City of Albuquerque Stormwater Construction Site Inspection Report

ESC File No.	J10E049	Project Name:	Coors/Bluewater (San Roque/La Serena)		
NPDES Id. No.	NMR10058F	Location:	457 Coors Blvd NW		
3/12/2025	Owner	Contractor			
Operator	Thomas Development	HB Construction			
Contact name & title	Thomas Mannschreck	Jacob Tonks			
e-mail	tmanschreck@thomasdevelopment.com	jacobt@hbconstruction.com			
Contact Phone #	208-343-8877	505-549-2189			
COA Inspector	Chancellor English	Start/End Time:	1:15pm		
Construction Phase:	verticals				
Type of Inspection:	<input checked="" type="checkbox"/> Regular	<input type="checkbox"/> Storm Event	<input type="checkbox"/> Post Storm Event >0.25"	<input type="checkbox"/> 311/Complaint	<input type="checkbox"/> Follow Up
Weather at time of inspection?	clear		Temperature: ~	60	
Estimated date of last storm 0.25" or greater	11/7/2024

SEDIMENTATION/SILT FENCE WITH WIRE SUPPORT
N.T.S. (SF)

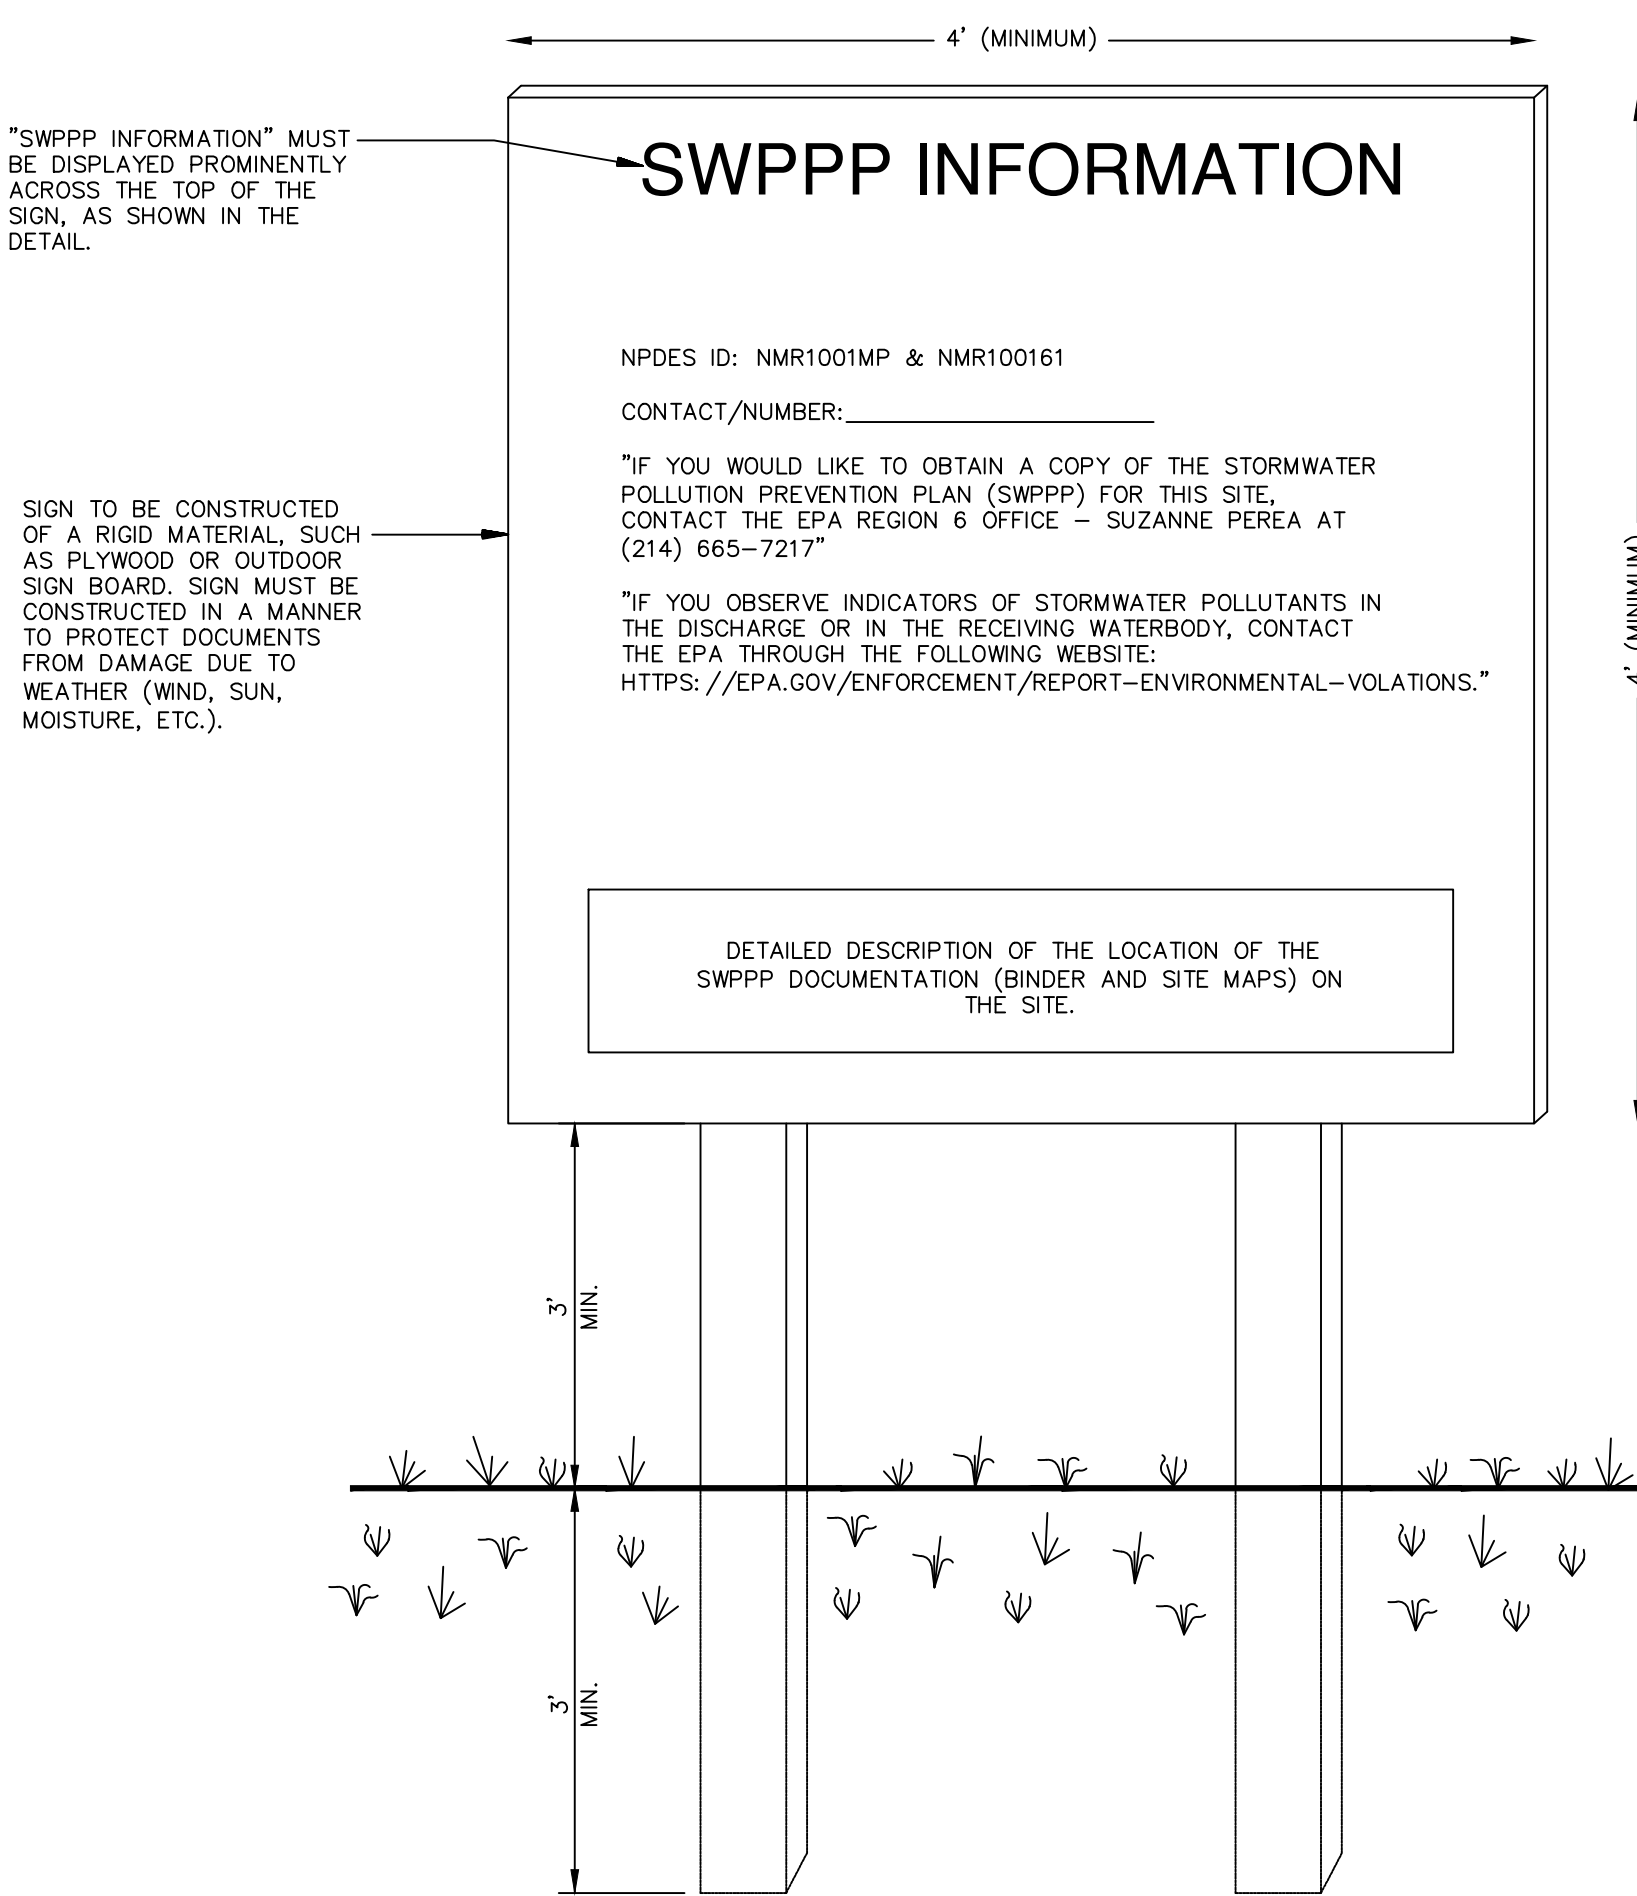
Item Number	Deficiency/ Corrective Action				
1	BMPs - The perimeter silt fence needs repair and maintenance in violation of CGP Part 2.1.4. Required mitigation: Ensure all stormwater controls are maintained and remain in effective operating condition during permit coverage and are protected from activities that would reduce their effectiveness per CGP Part 2.1.4.
